Our Ref: ID 3496  
Your Ref: SSD-86017721

**Environmental Impact Assessment for Residential development with in-fill affordable housing, 23-31 Dover Road, Rose Bay**

Thank you for the opportunity to provide comment on the Environmental Impact Assessment (EIS) for the State Significant Development (SSD) Residential development with in-fill affordable housing at 23-31 Dover Road, Rose Bay (SSD-86017721). It is understood that the project seeks consent for:<sup>1</sup>

**Figure 2 :
Peak Floodwater Depths and
Levels for the 100 Year ARI
Flood for Existing Conditions**

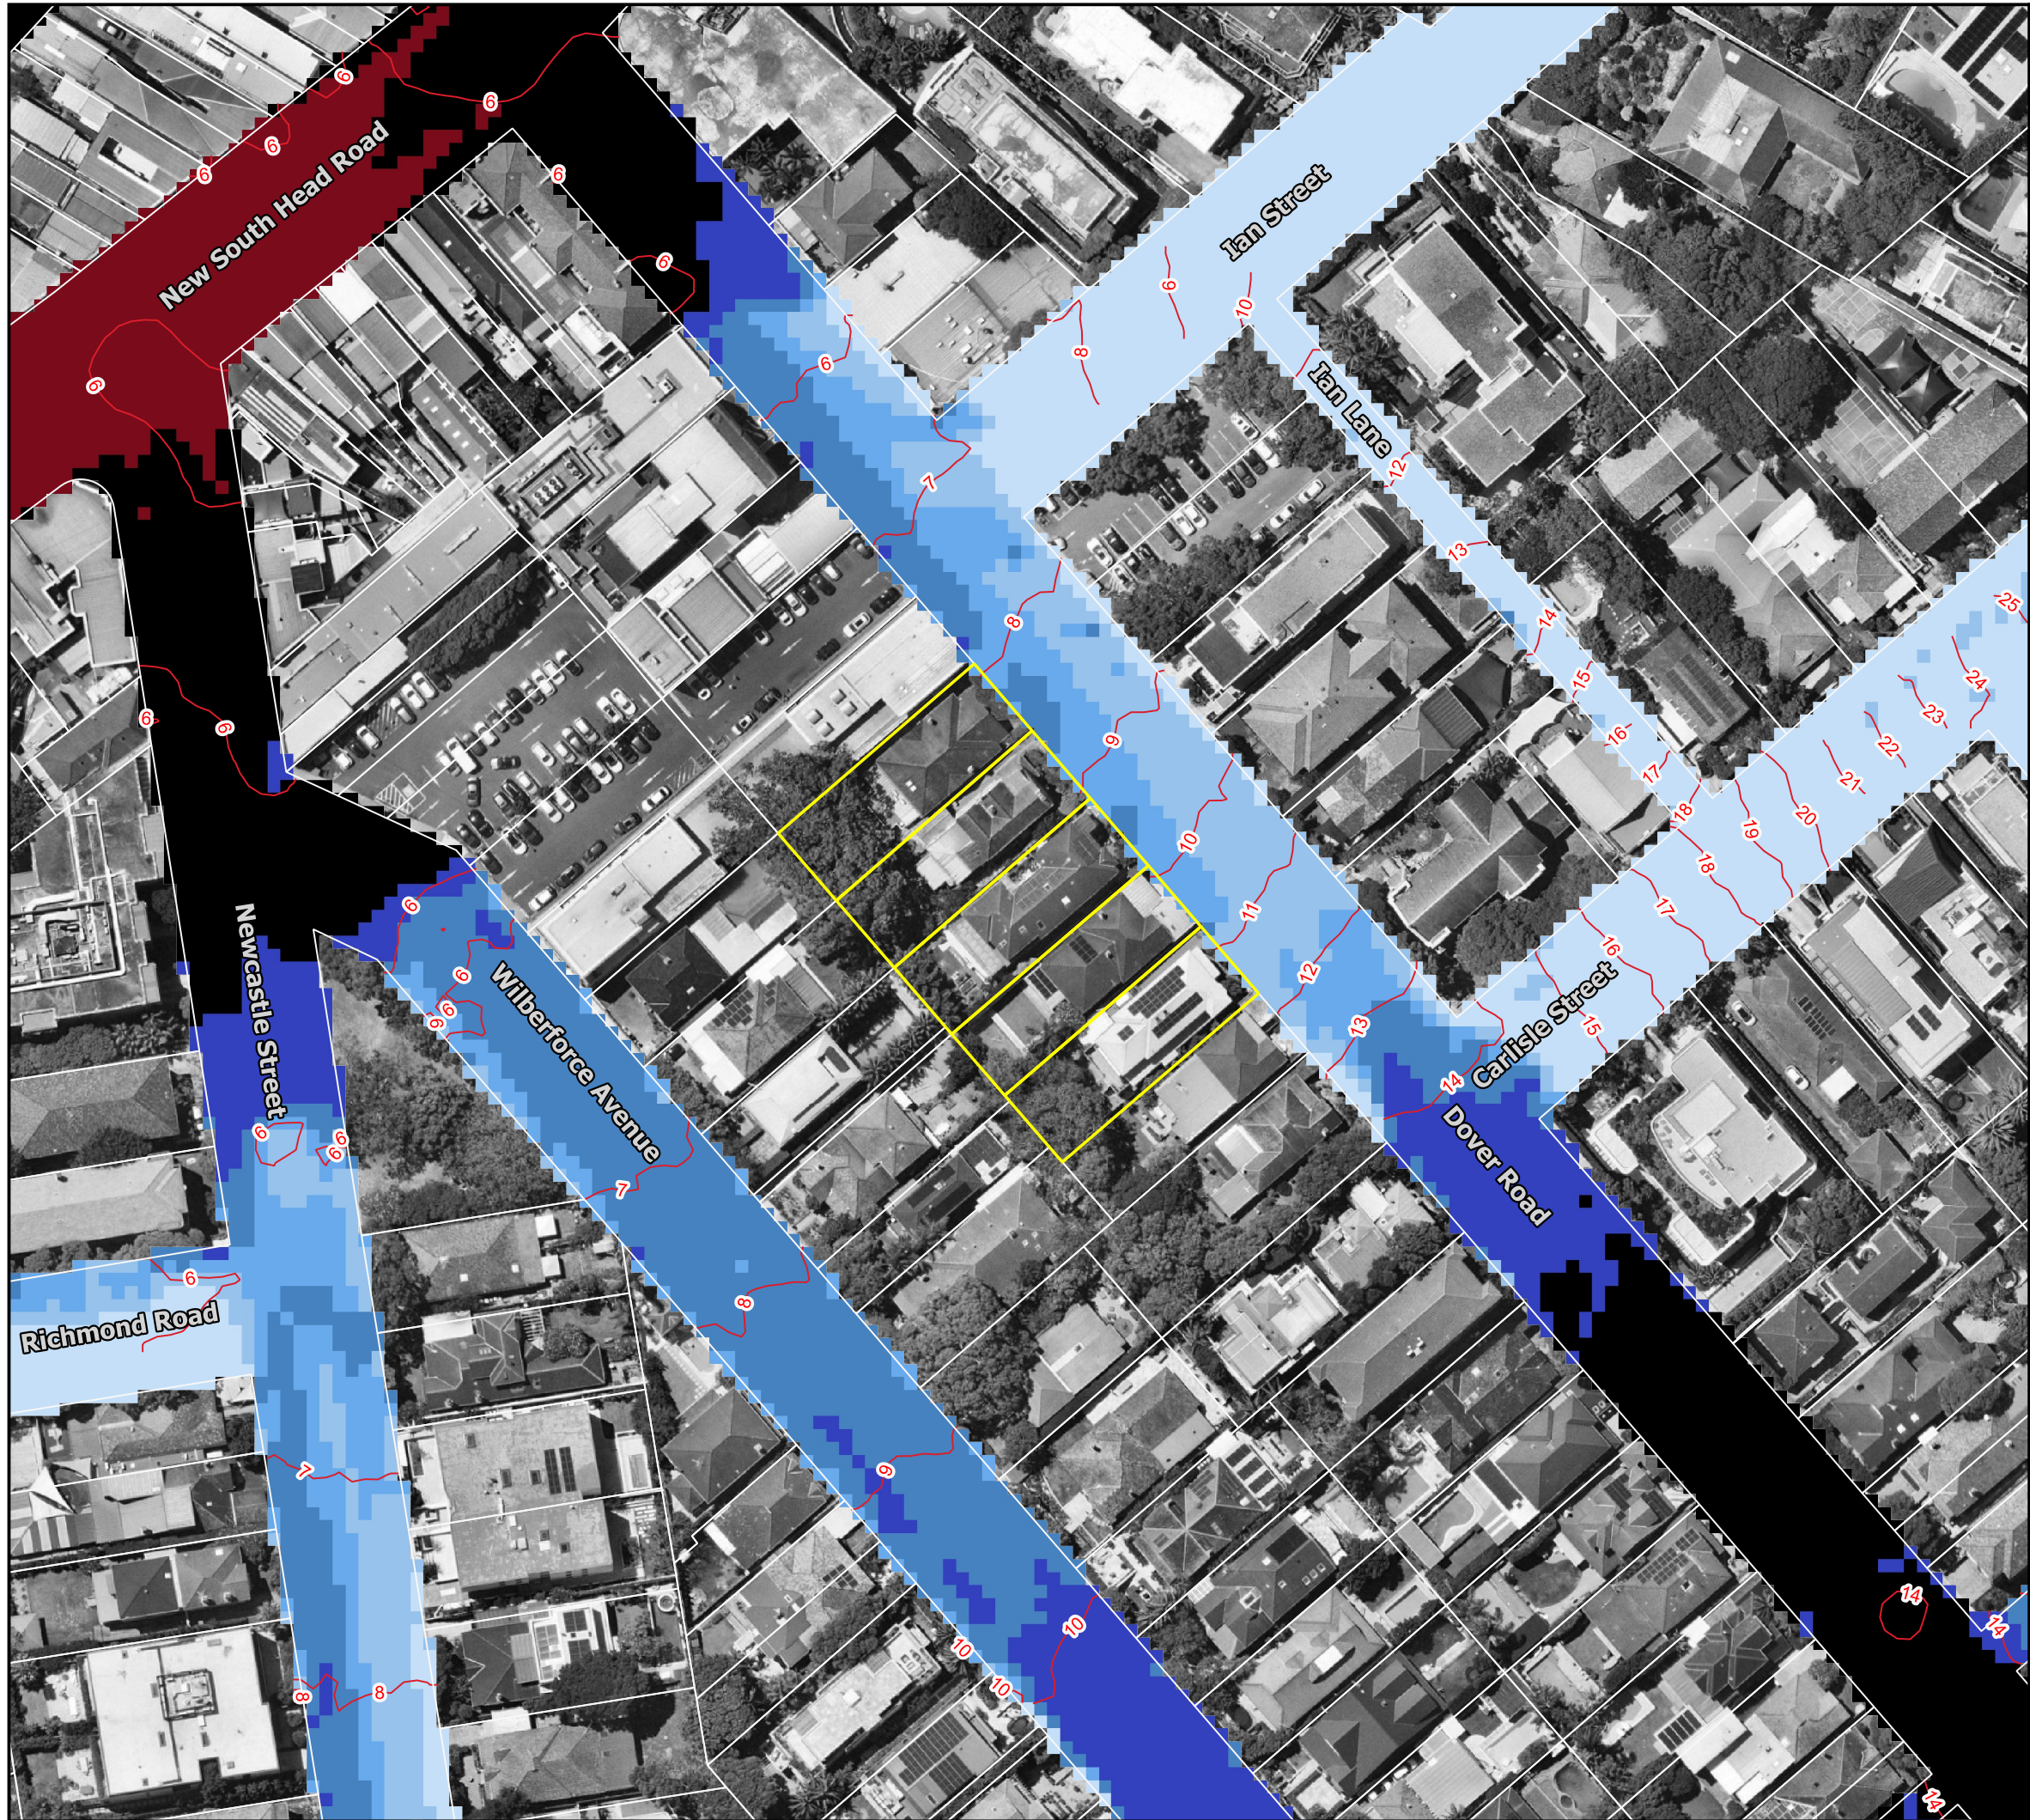
It is understood that inundation in the 20-year ARI, 100-year ARI and PMF events extends across the full width of Dover Road along the site frontage, with peak depths adjacent to the site frontage of up to 0.15 metres in the 20-year ARI event, 0.25 metres in the 100-year ARI event, and 0.40 metres in the PMF.<sup>26</sup> However, according to the mapping provided, Dover Road further east (at the New South Head Road intersections) and west (around the Carlisle Street intersection) of the site can experience up to 1 metre flood depth in the 100- year ARI event, and up to 2 metres in a PMF event.<sup>27</sup> *"Peak velocities can vary from between 2 and 3m/s in the 20-year ARI event, to 6m/s in the PMF. **The floodway hydraulic category is predicted along Dover Road in all flood events, together with H5 hazard in events up to the 100-year ARI, and H6 in the PMF. Flood behaviour of this nature is hazardous to people and vehicles**"*.<sup>28</sup>

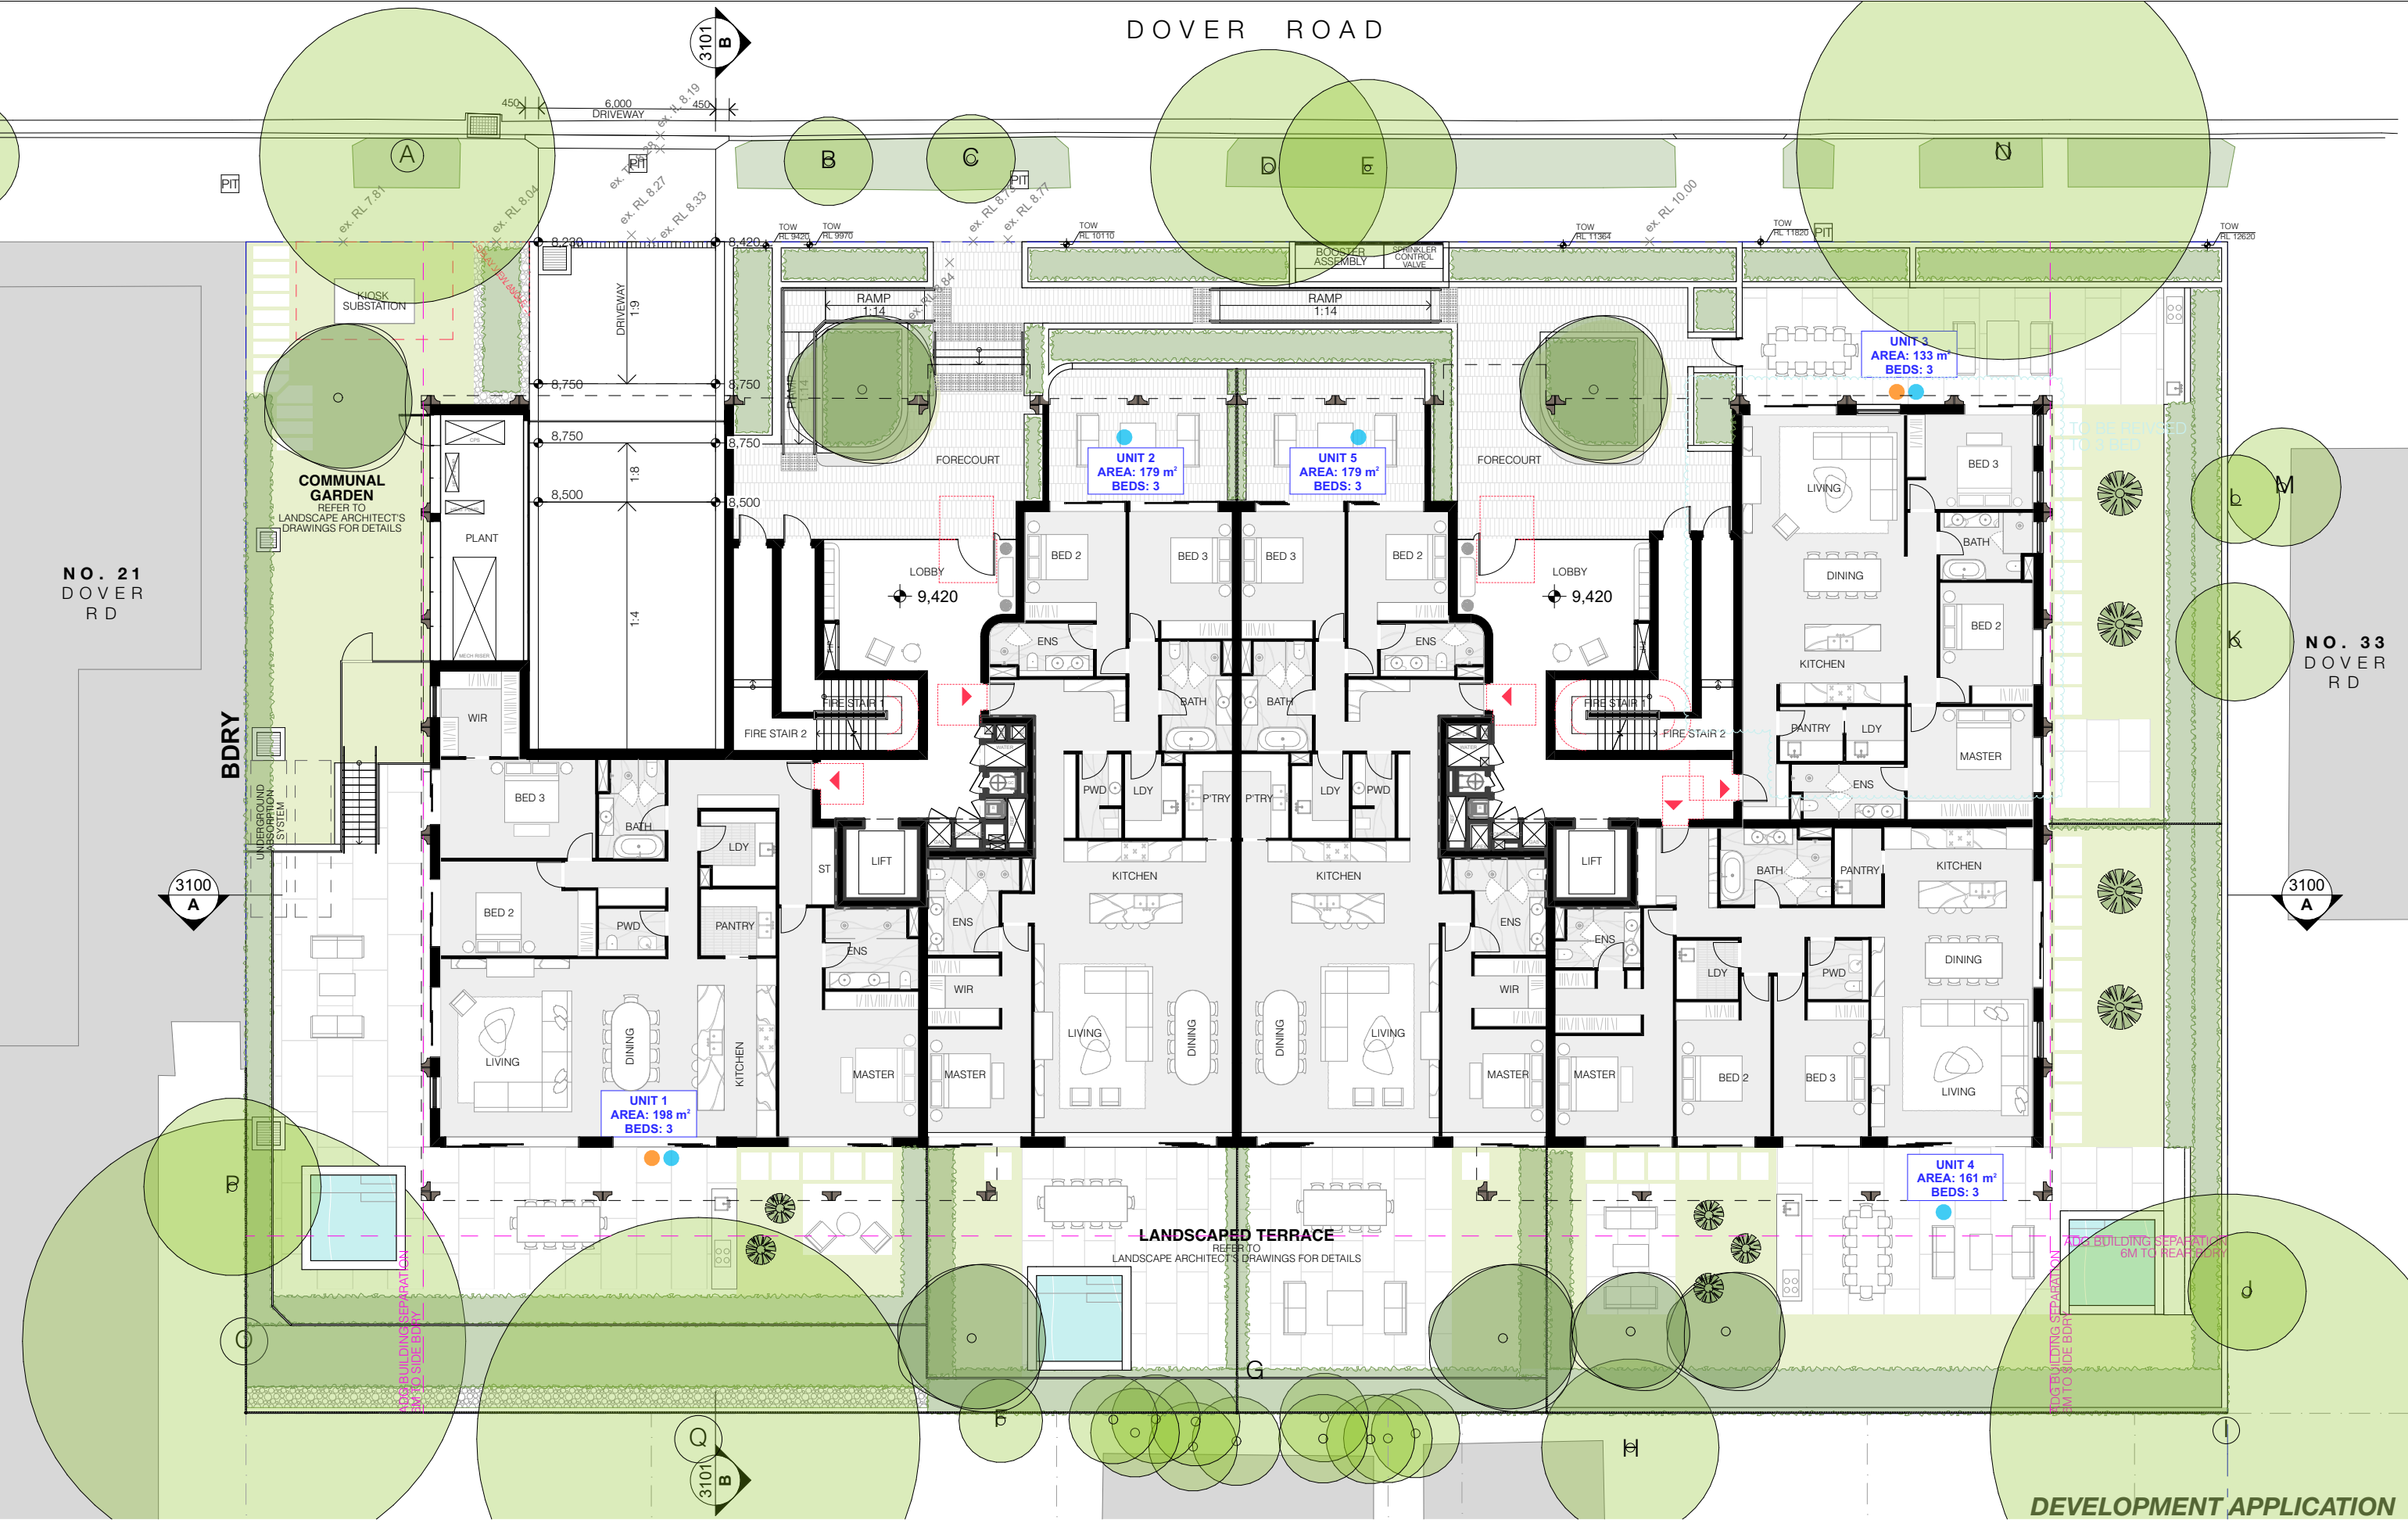
- an understanding of secondary risks and how the proponent proposes they will be managed – to be outlined in the FIRA (10)
- **Caution** that people sheltering in place in a location below the height of the PMF is inadequate, as it poses a significant risk to life, therefore we recommend the consent authority requests the proponent to **demonstrate** if *all habitable floor areas, as well as the basement, are protected to a level above the PMF*,<sup>4</sup> or if the ground floor level, which includes residential units<sup>5</sup> is proposed to be at 9.42m AHD (the peak 100-year ARI + 0.5 metres freeboard) and the basement driveway crest at 8.75m AHD (the peak 100-year ARI flood level + 0.3 metres freeboard).<sup>6</sup>

We also **caution** that people sheltering in place in a location below the height of the Probable Maximum Flood (PMF) is inadequate, as it poses a significant risk to life, therefore we recommend the consent authority requests the proponent to **demonstrate** if *all habitable floor areas, as well as the basement, are protected to a level above the PMF*,<sup>31</sup> or if the ground floor level, which includes residential units,<sup>32</sup> is proposed to be at 9.42m AHD (the peak 100-year ARI + 0.5 metres freeboard) and the basement driveway crest at 8.75m AHD (the peak 100-year ARI flood level + 0.3 metres freeboard).<sup>33</sup>
